Modification request – Woodlawn Bioreactor MP 10-0012 MOD and DA Q91/00233 MOD2

Thank you for your invitation to provide comments on Veolia Environmental Services (Australia) Pty Ltd's application to modify the project approval for the Woodlawn Bioreactor at Collector Road, Tarago. The application seeks to modify the stormwater and leachate management system at the site.

CATE WOODS
Unit Head Waste Compliance
Environment Protection Authority

**Figure 3:** Detail of Evaporation Dam 3 (Source: Proponent).  
**Note.** Pipelines and location of dams are show for illustration purposes only

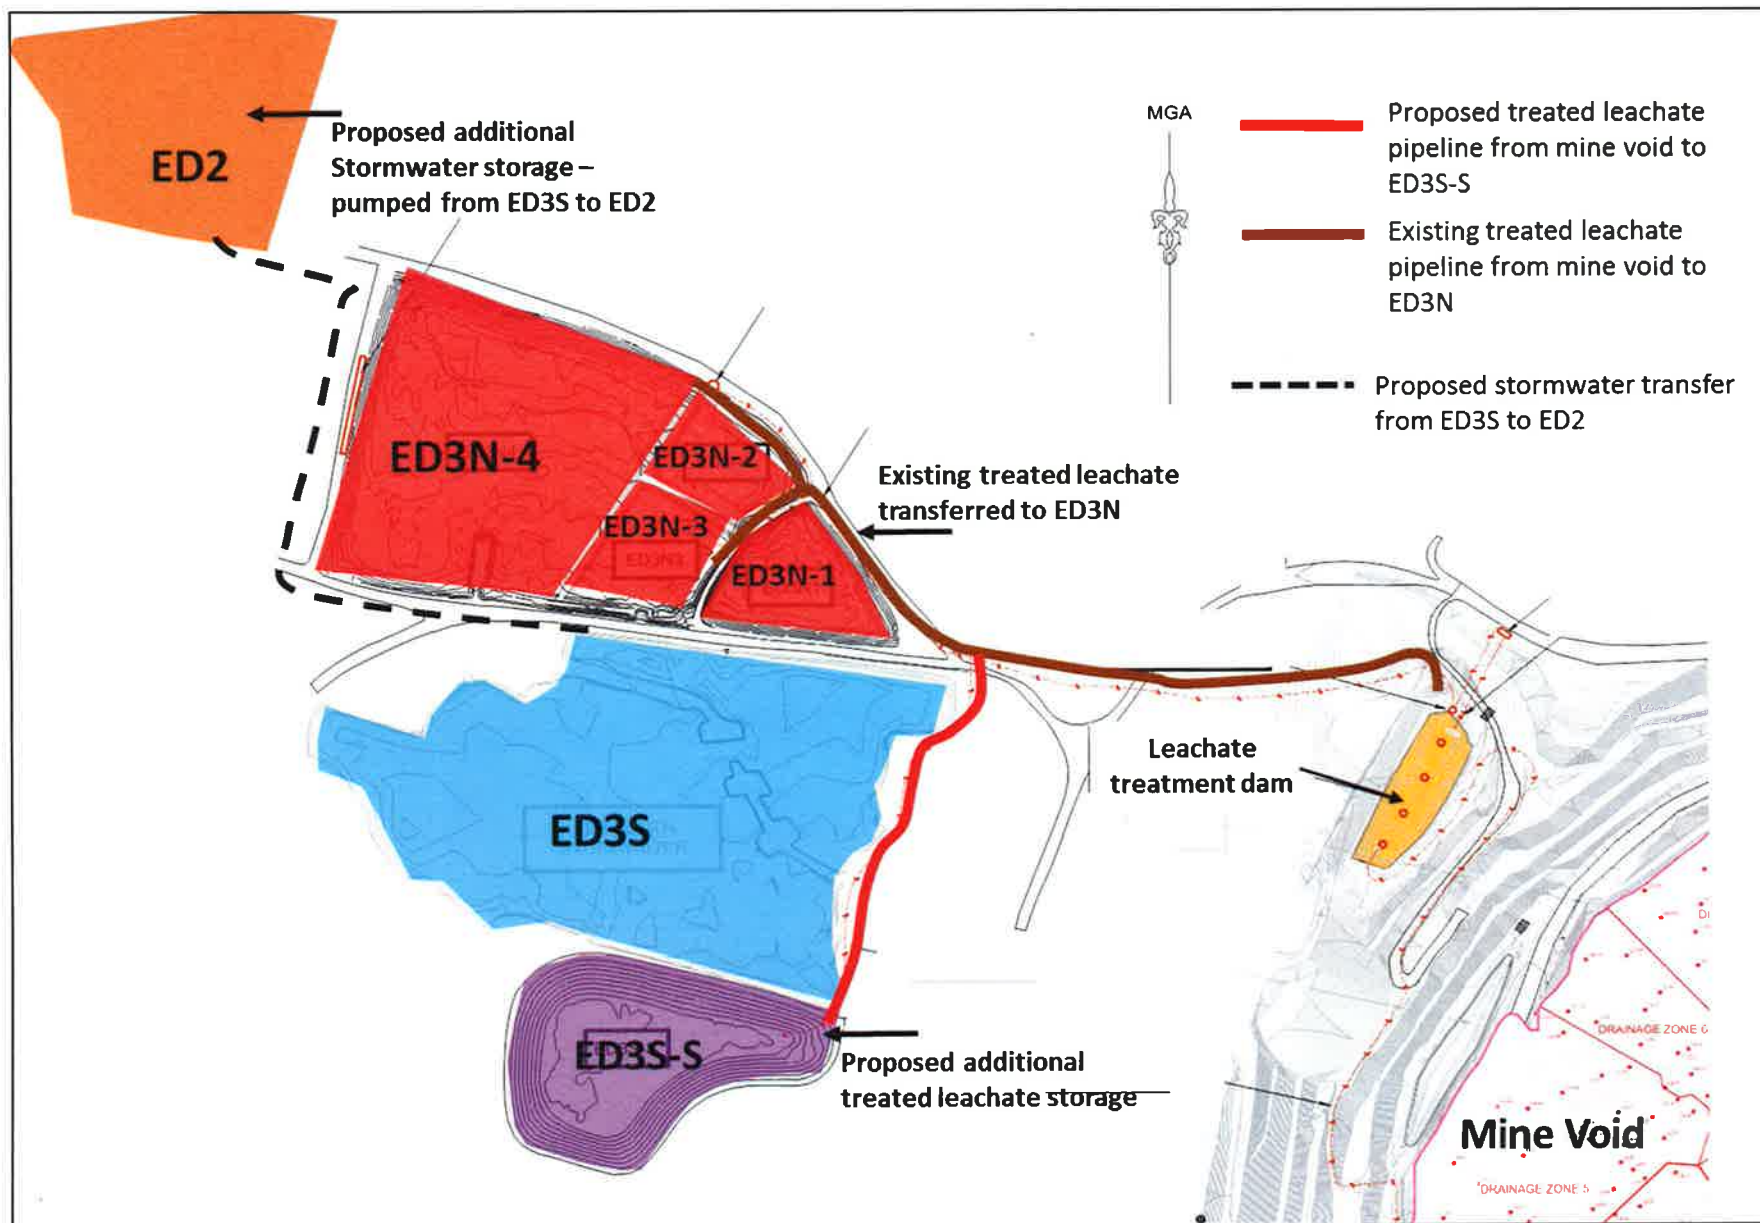
If the proposed modification is approved, the dam area for treated leachate storage will increase from 42,000 m² to 160,000 m², an increase of 380%. The Odour Assessment (OA) submitted with the application estimates that this will increase odour emissions from this source by 18,700 ou.m³/s and will increase overall odour emissions from the premises by up to 17%.

The OA states that this increase is insignificant and will not cause offsite impacts given the distance of the odour source from potential receptors (the closest receptor being 1.6km from the Woodlawn site) and the character of the pond emissions being relatively neutral (described as earthy/mildly ammoniacal). The EPA does not support this assertion and recommends that the Department seek further justification of this from the proponent. This is important given the numerous complaints about offensive odour the EPA has received from residents living much further away from the facility than 1.6km and the fact that the statements made in the OA were made in the absence of any odour dispersion modelling.

- The predicted reduction in odour emissions from the void that will be achieved if leachate levels in waste are better controlled.
- The quality criteria that will be observed to ensure that treated leachate transferred to ED3S does not become more odorous than predicted.
- The monitoring program that will be implemented to monitor the quality of treated leachate in ED3S and its potential to generate offensive odours.
- The contingency measures that will be implemented to manage odour emissions from ED3S should emissions be higher than predicted.
